# SITE DEVELOPMENT PLAN - DWIRE YARD

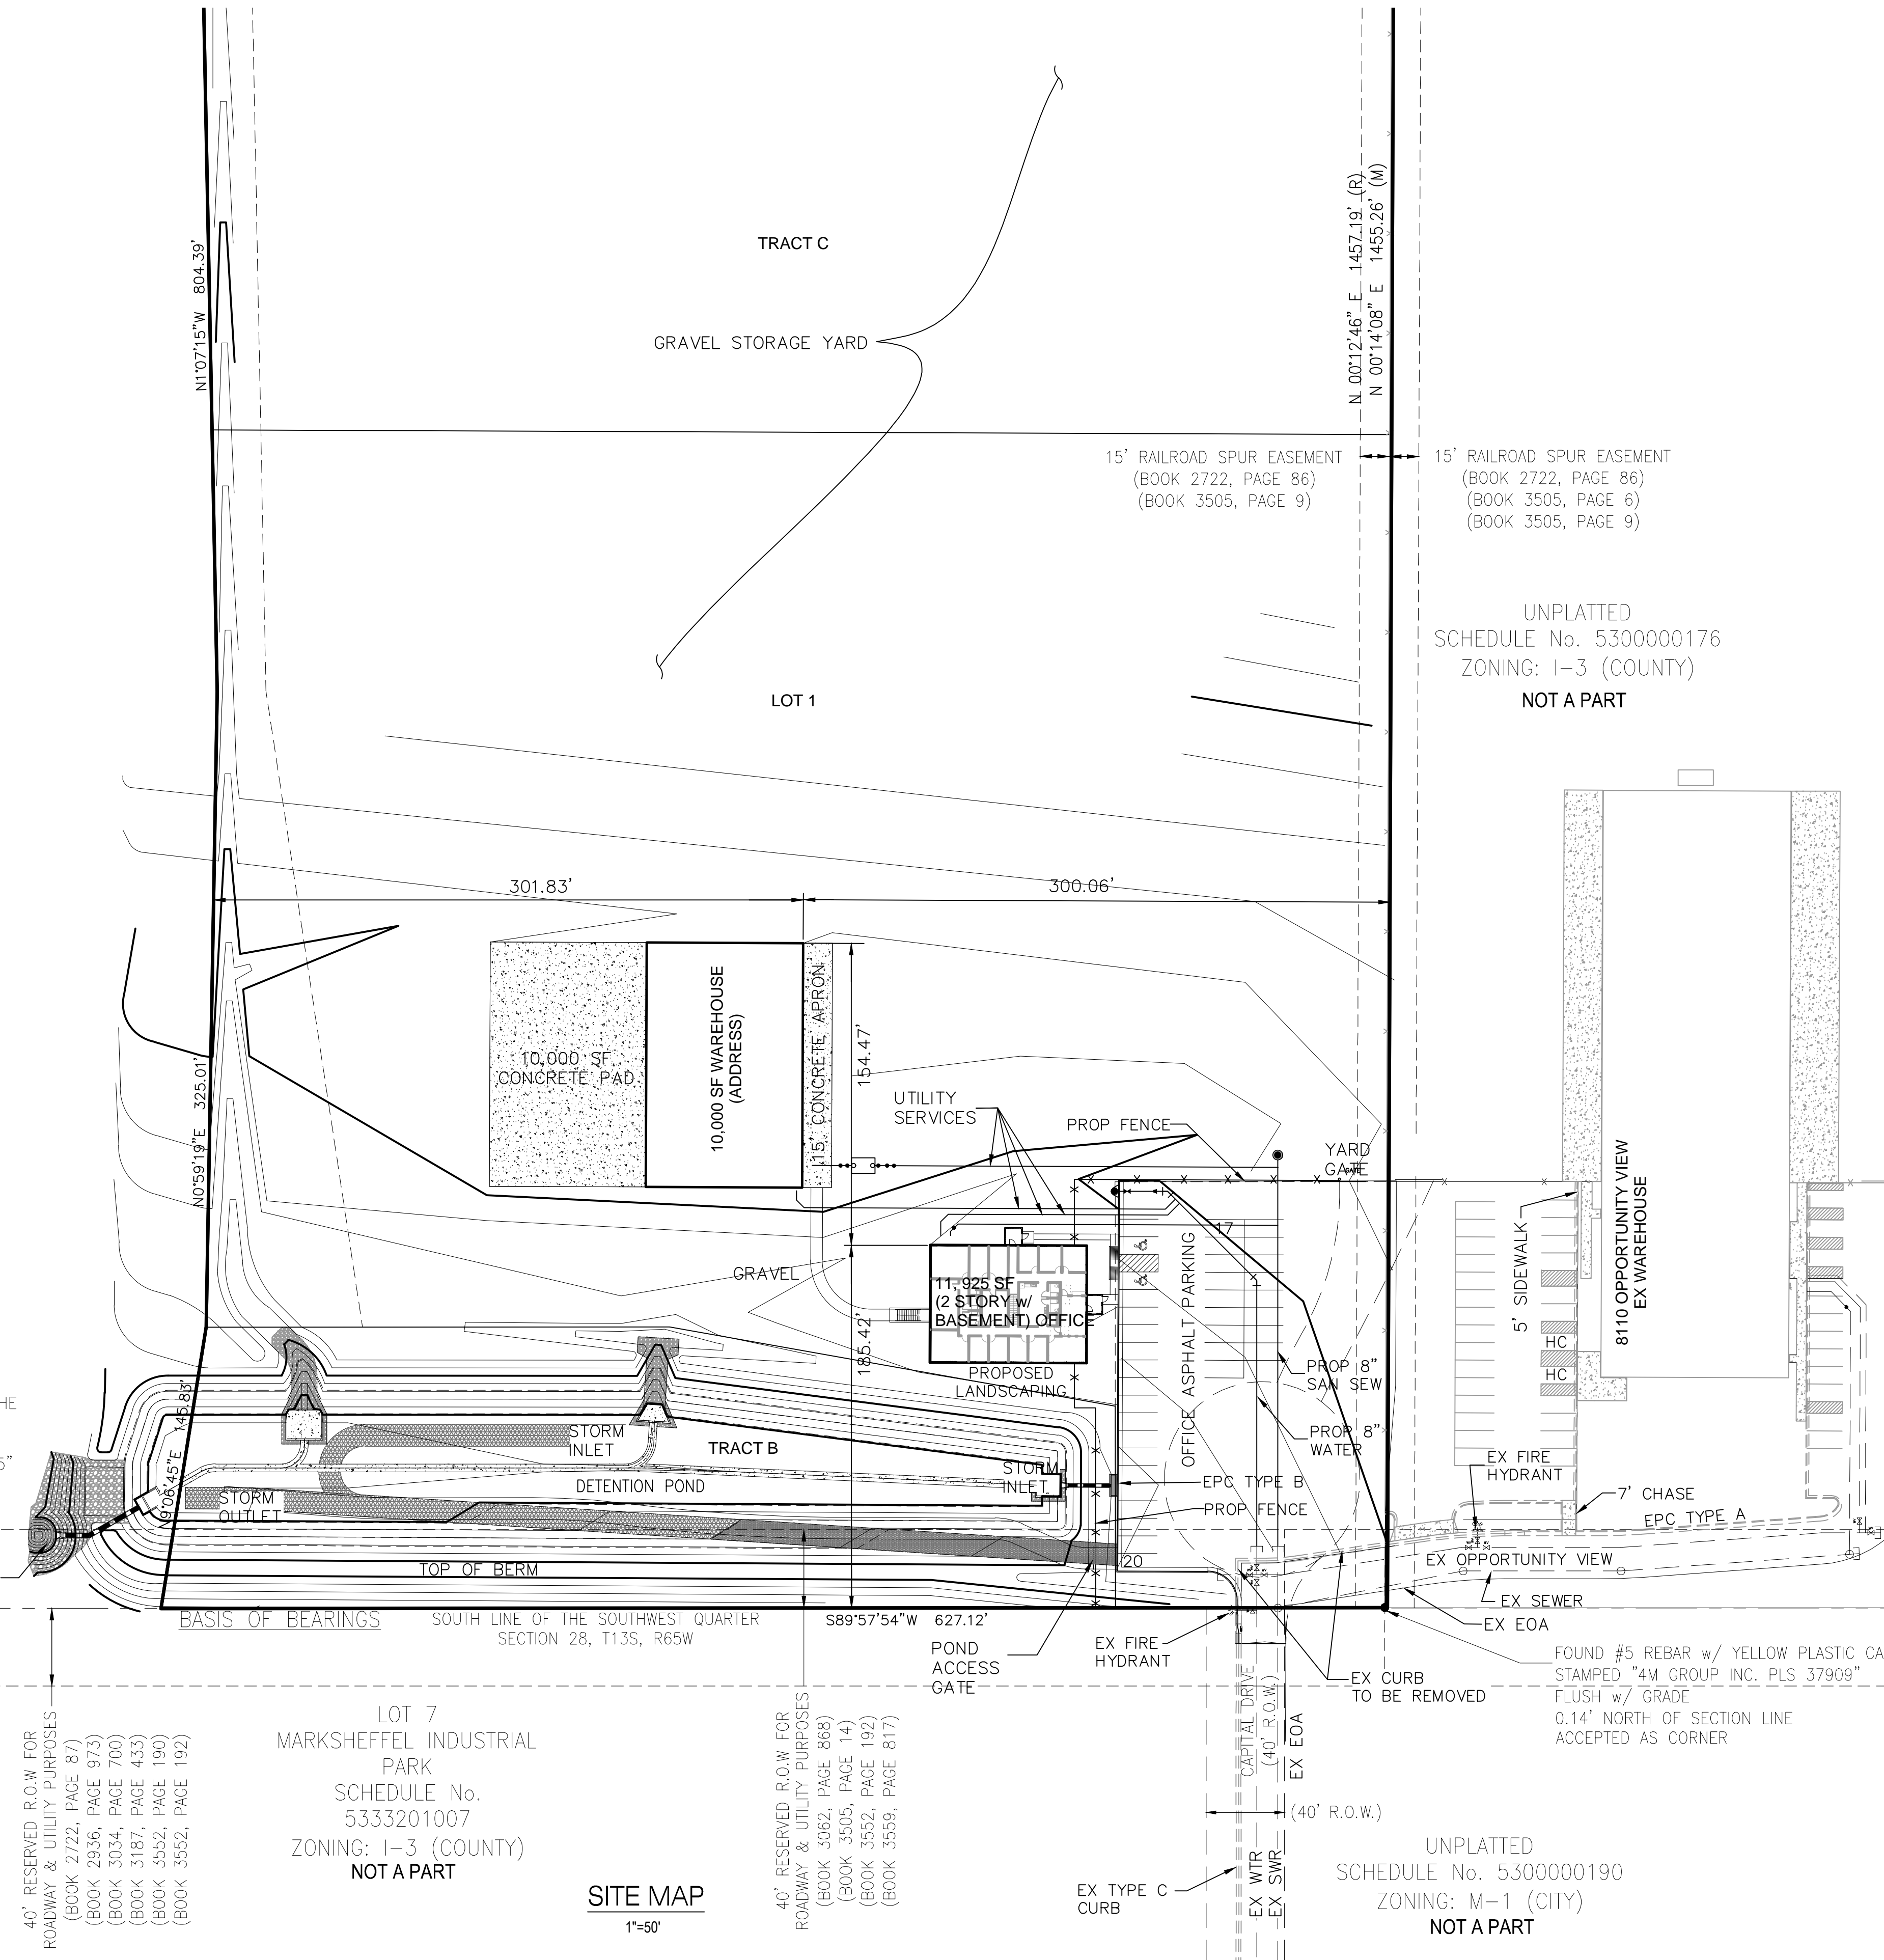
See comments on the subdivision (MS-20-002). Show and label all uses and restricted/no-disturbance areas on the SDP. Provide fencing or other method of delineation to keep uses out of the no-build/no-disturb areas and comply with MS4 permit requirements.

Ensure that the SDP matches the latest MS drainage and grading plans.

PLEASE SEE REVISED PLANS AND DOCUMENTS – The back (North) portion of the site has been delineated as Tract C – “No Build” area.

**TIMBERLINE Landscaping**  
A TIMBERLINEONE Company  
8110 Opportunity View  
Colorado Springs, CO 80939  
(719) 638-1000 fax (719) 638-1010

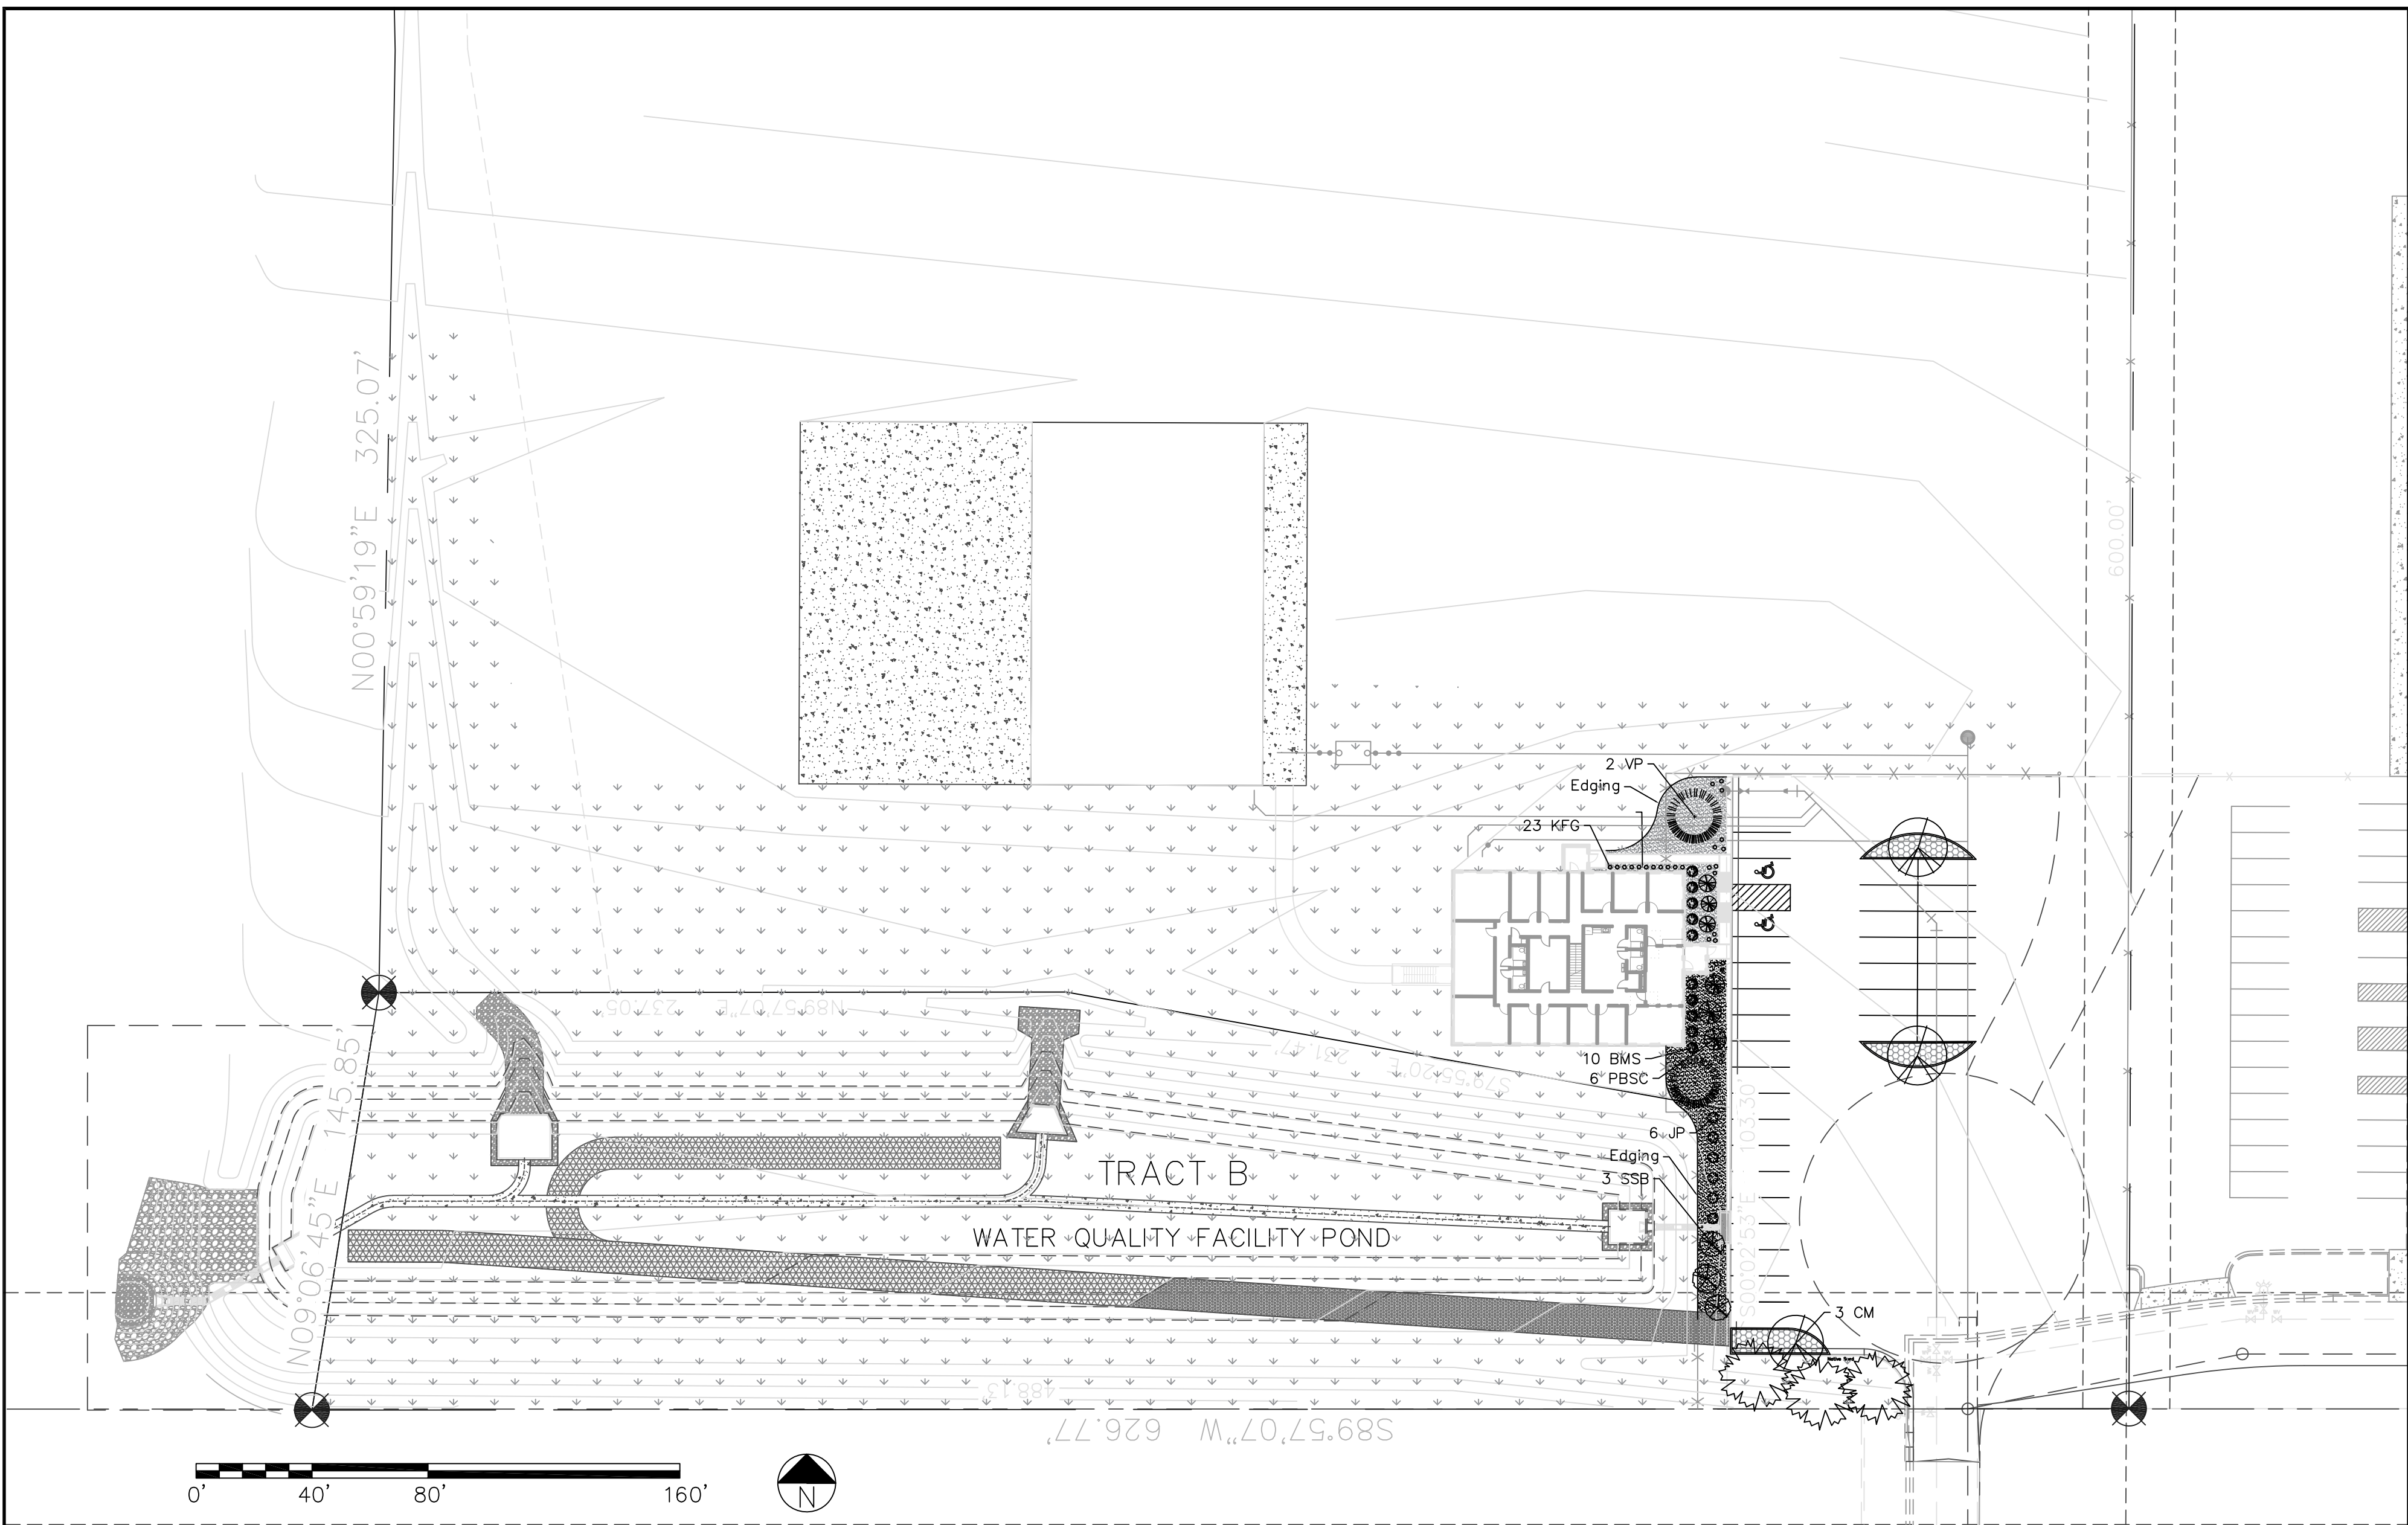
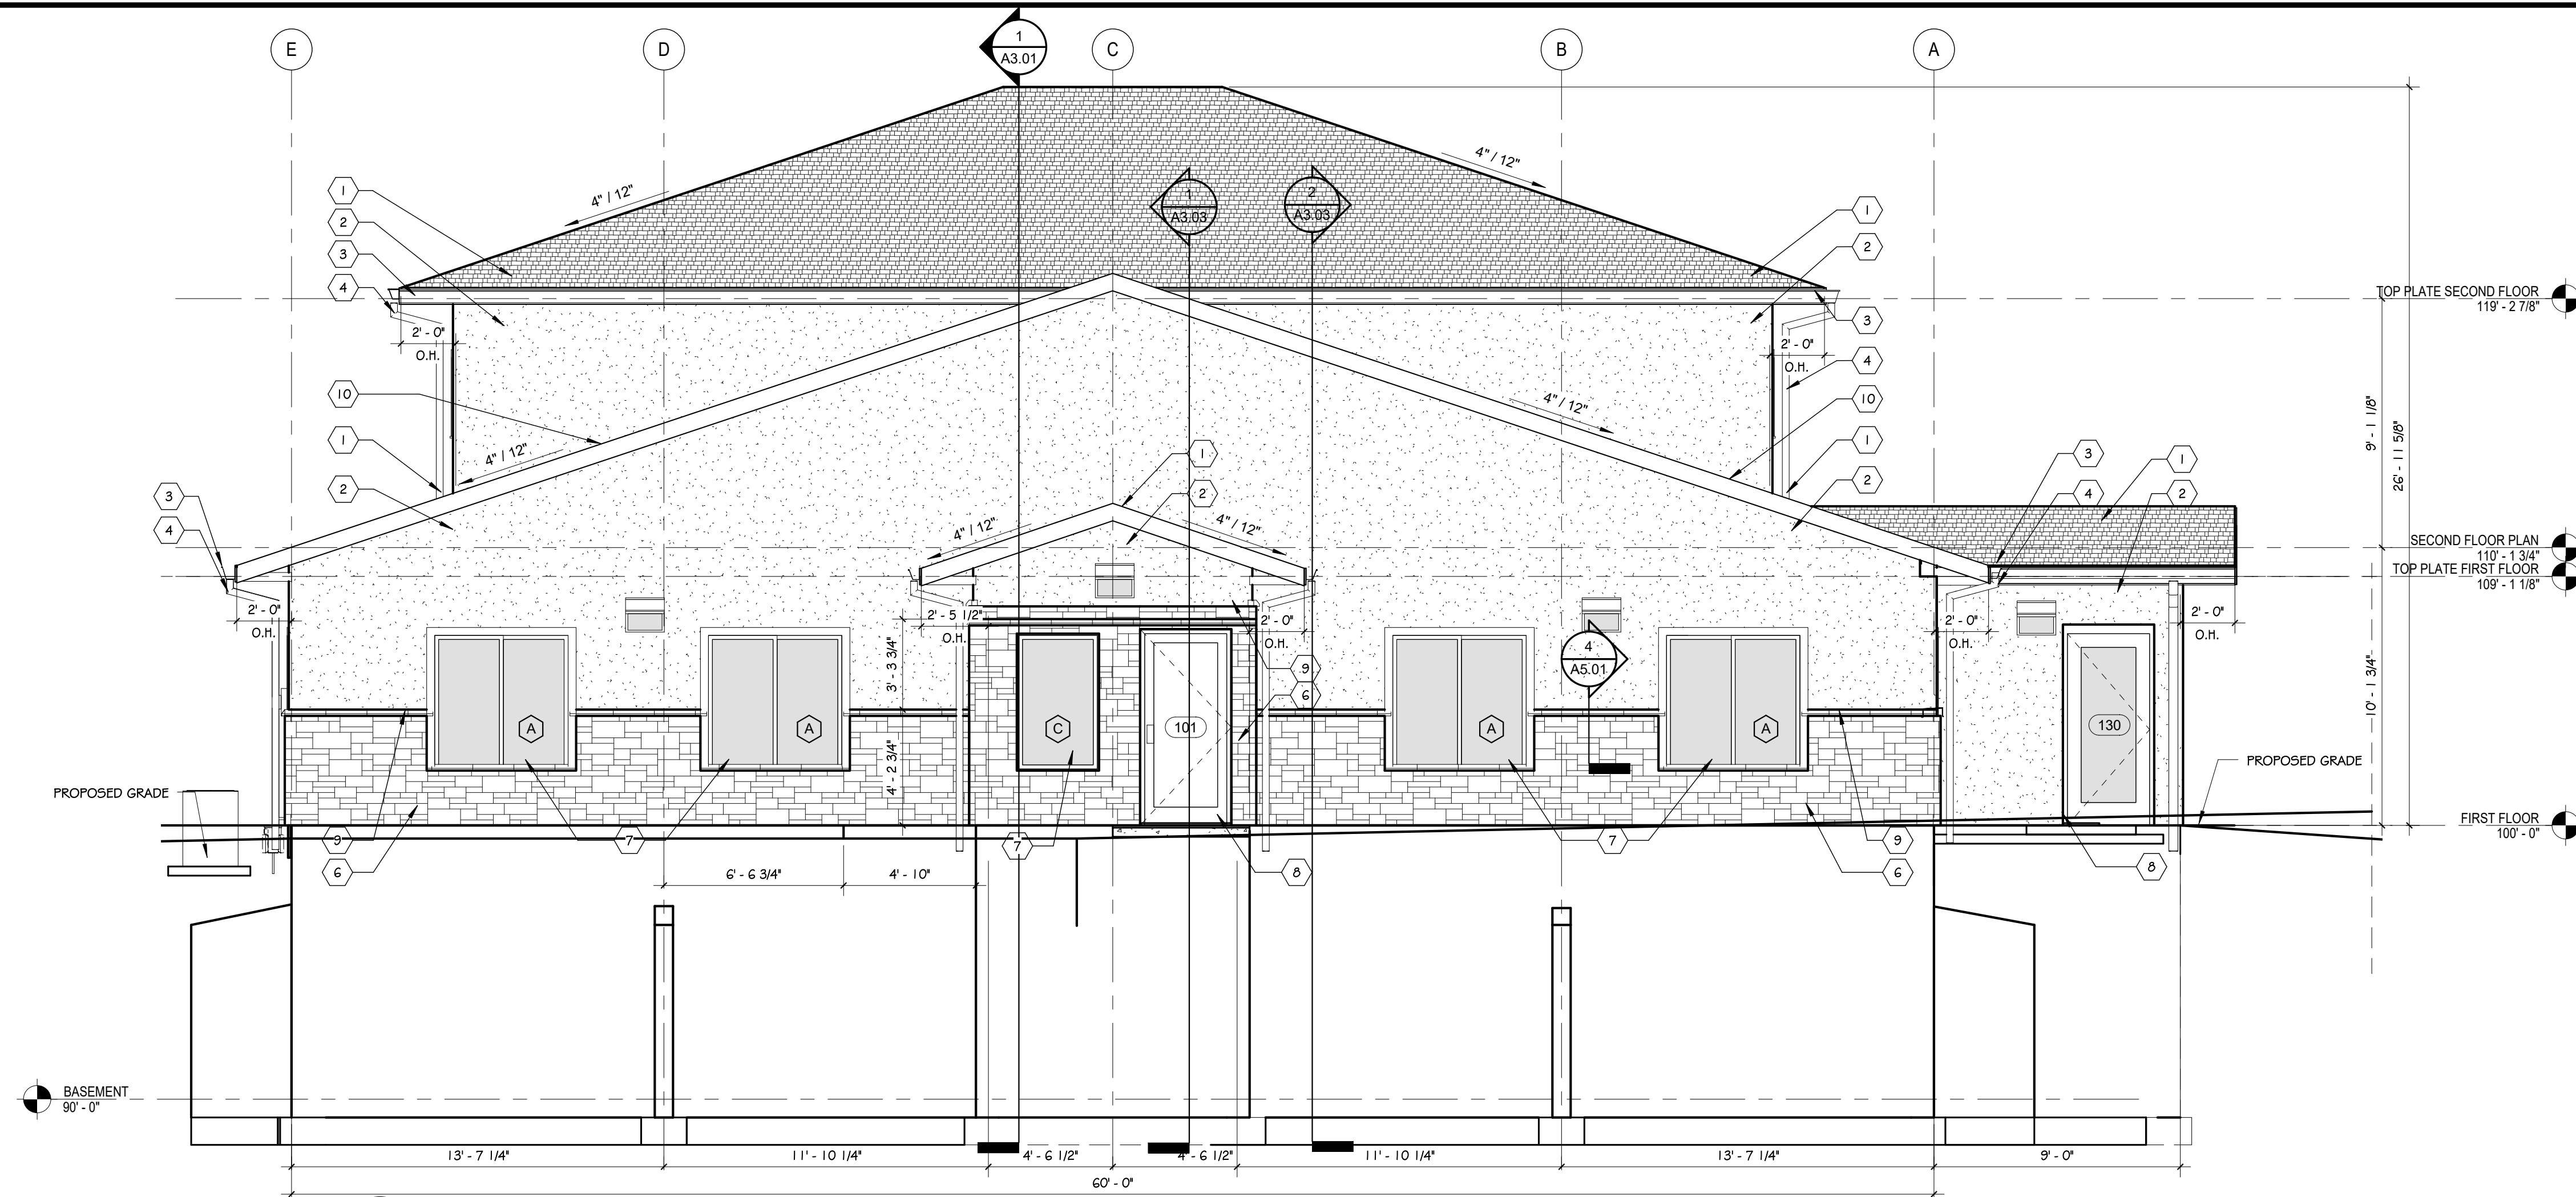
Landscaping Plan: Trees, shrubs, and/or any type of woody vegetation should not be placed on the detention pond embankment. If landscaping is required along the south property line ensure that there is enough space between the embankment and the plantings to maintain both.
